December 25, 2023

Re: Framing Inspection
1263 -1283 Moore Chapel Road
Lillington, NC 27546
Project #23271

You are the contractor for the construction of a new house at the referenced address above. You recently had a framing inspection. There were six (6) framing issues as listed below. I made a site visit to inspect these issues and to determine if modifications were required.

Title:
ELEVATIONS 'B'
2nd FLOOR FRAMING

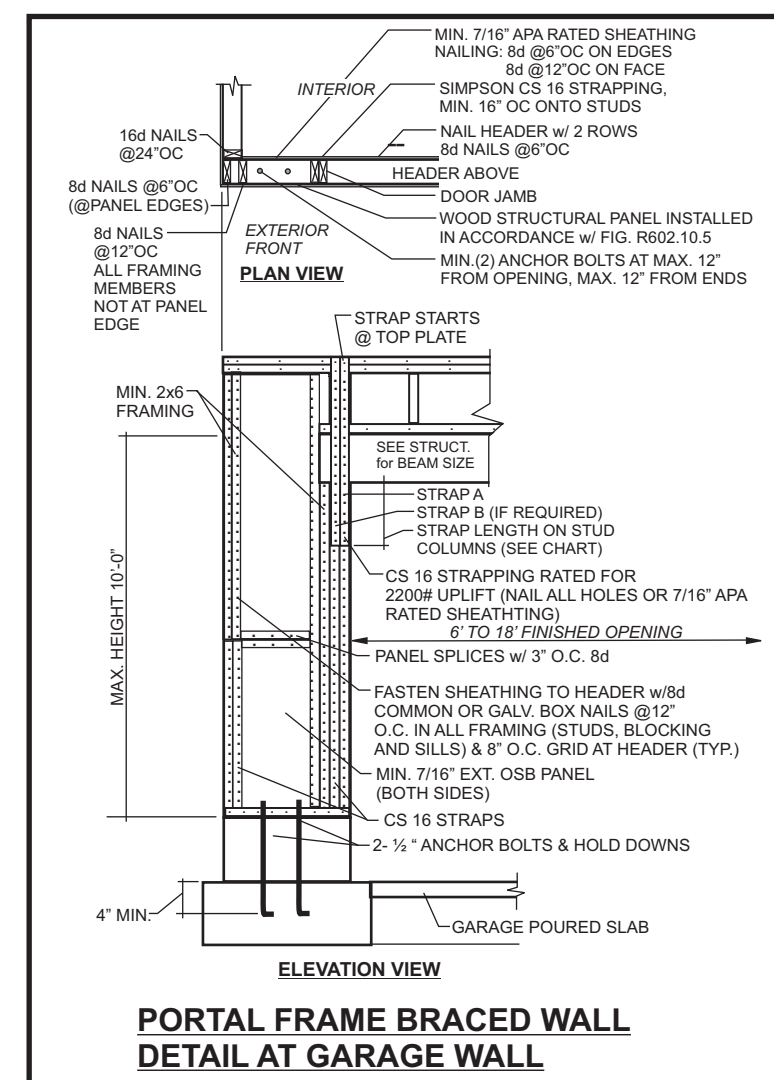
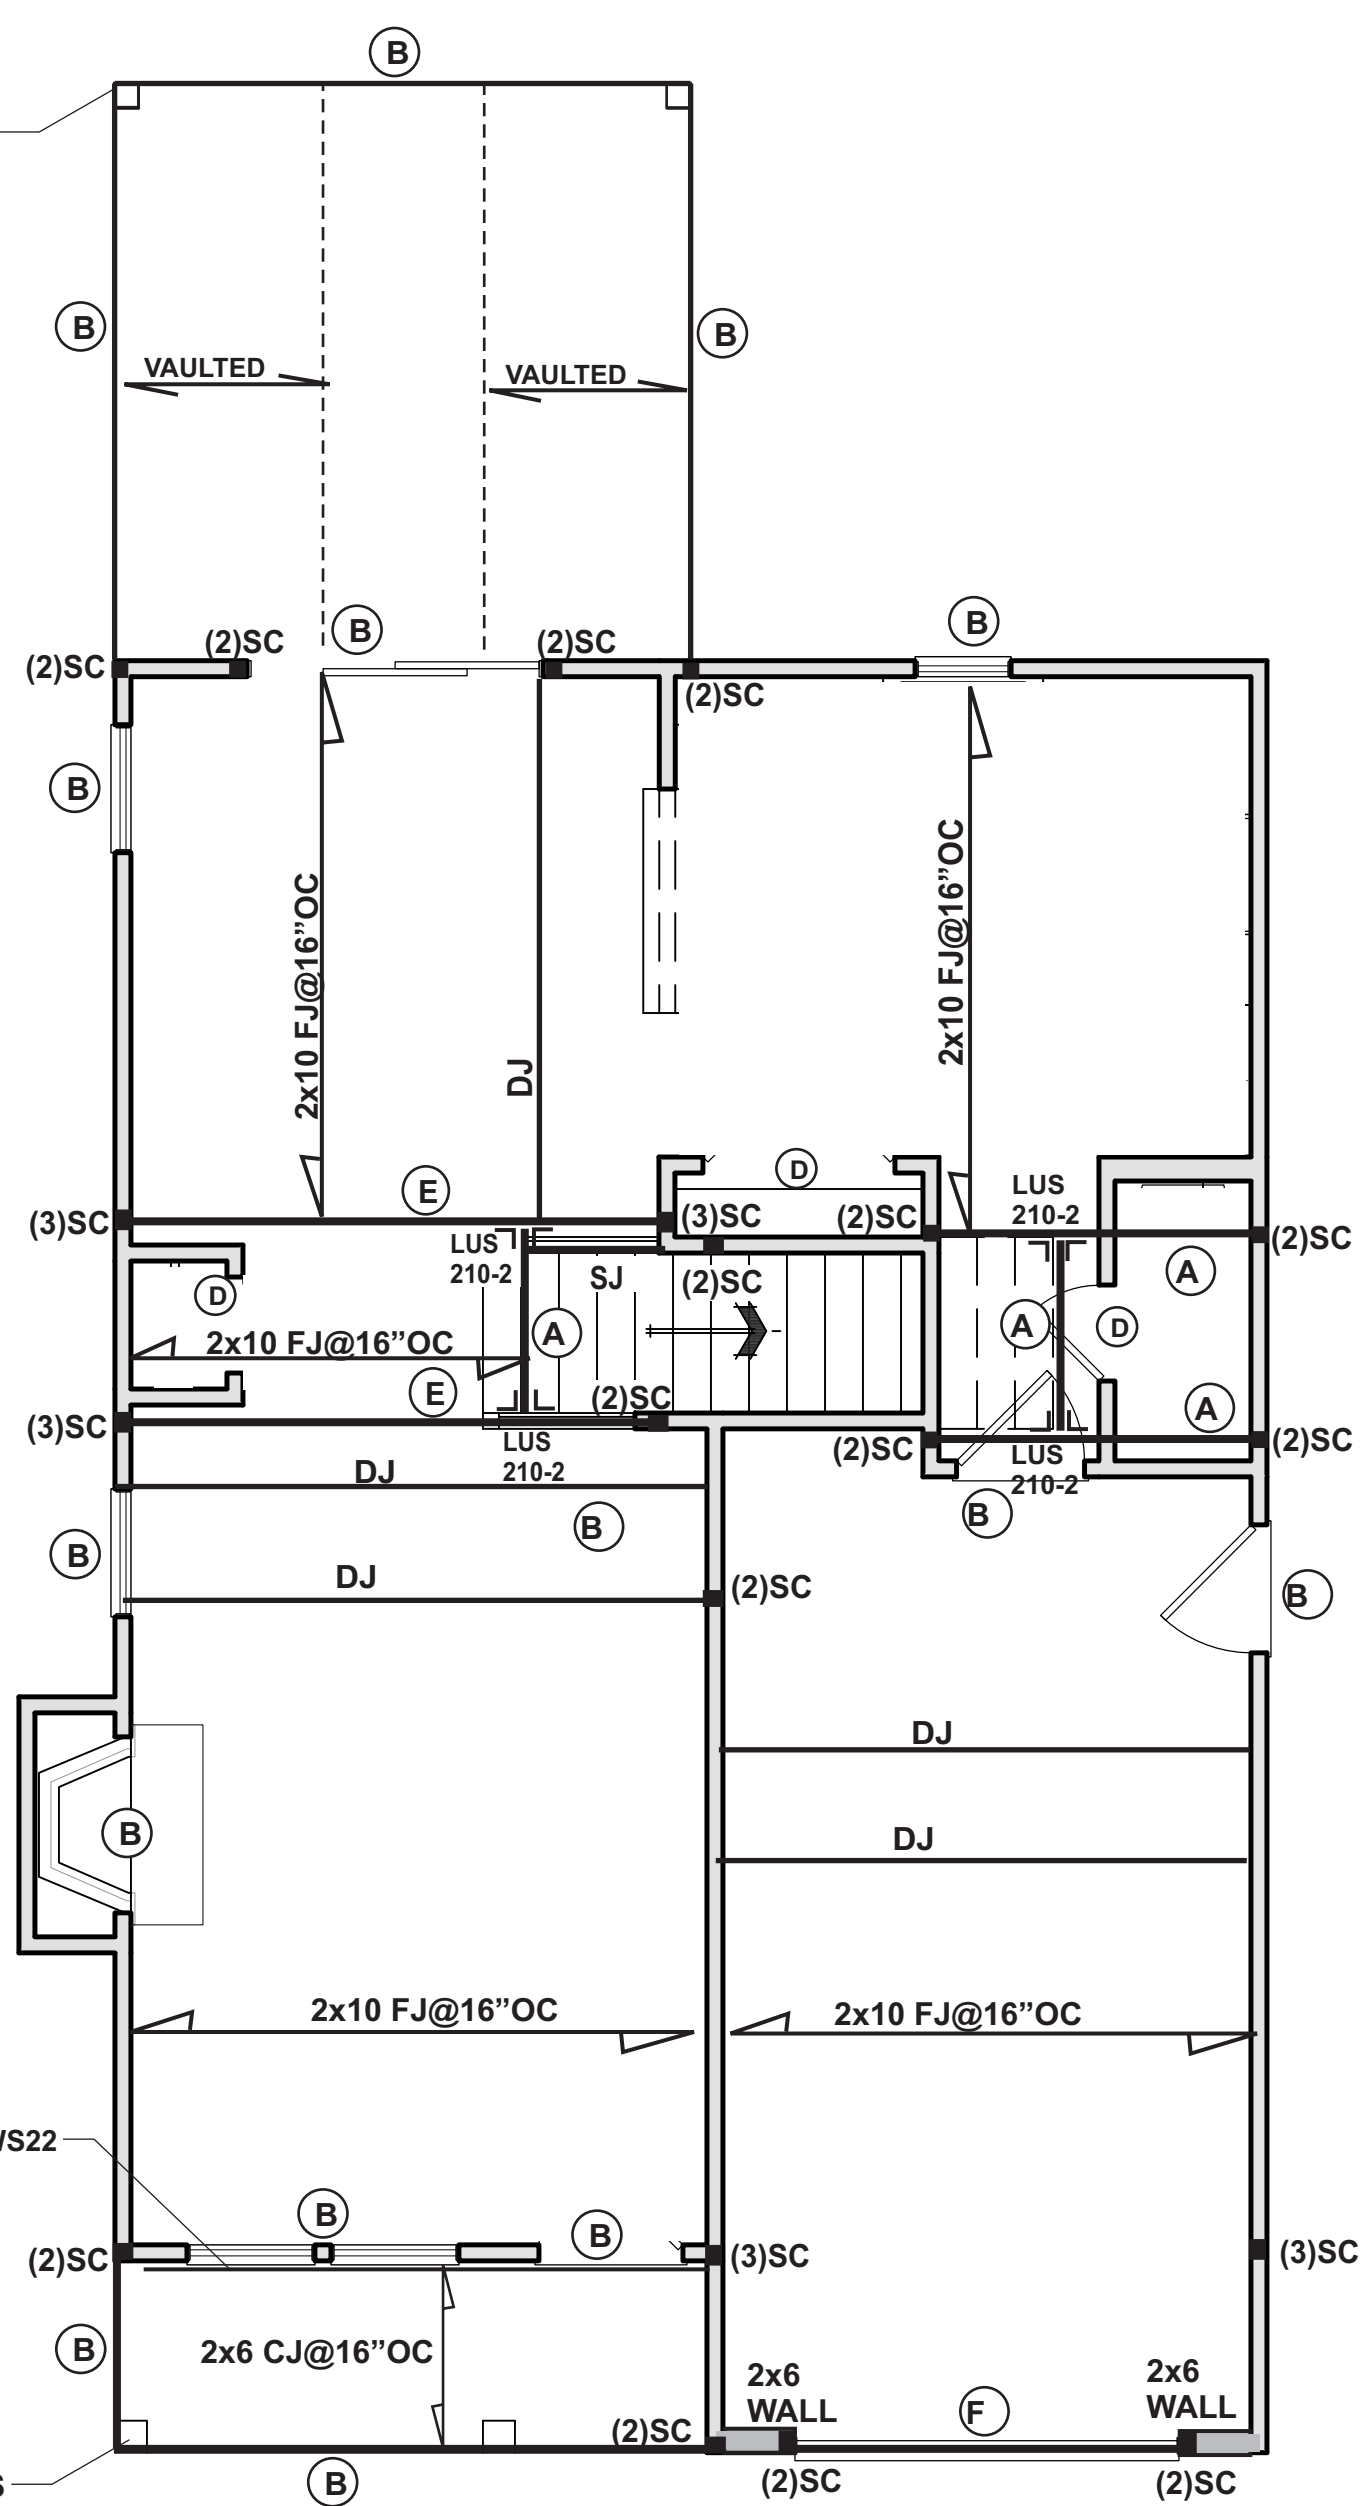
2. Issue: The second-floor framing in the garage was modified due to the installation of drain lines.
Solution: The framing is done correctly. No modifications are required.

5. Issue: The king studs at the second-floor front double window is in question.
Solution: This window framing was done correctly.
6. Issue: The second-floor framing in the living room was modified due to the installation of drain lines. The building code requires a minimum of 2" below drain pipes cut through floor joists. These joists have only 1 1/2".

Solution: I performed the necessary calculations and determined that the floor joists meet the code in their current configuration.
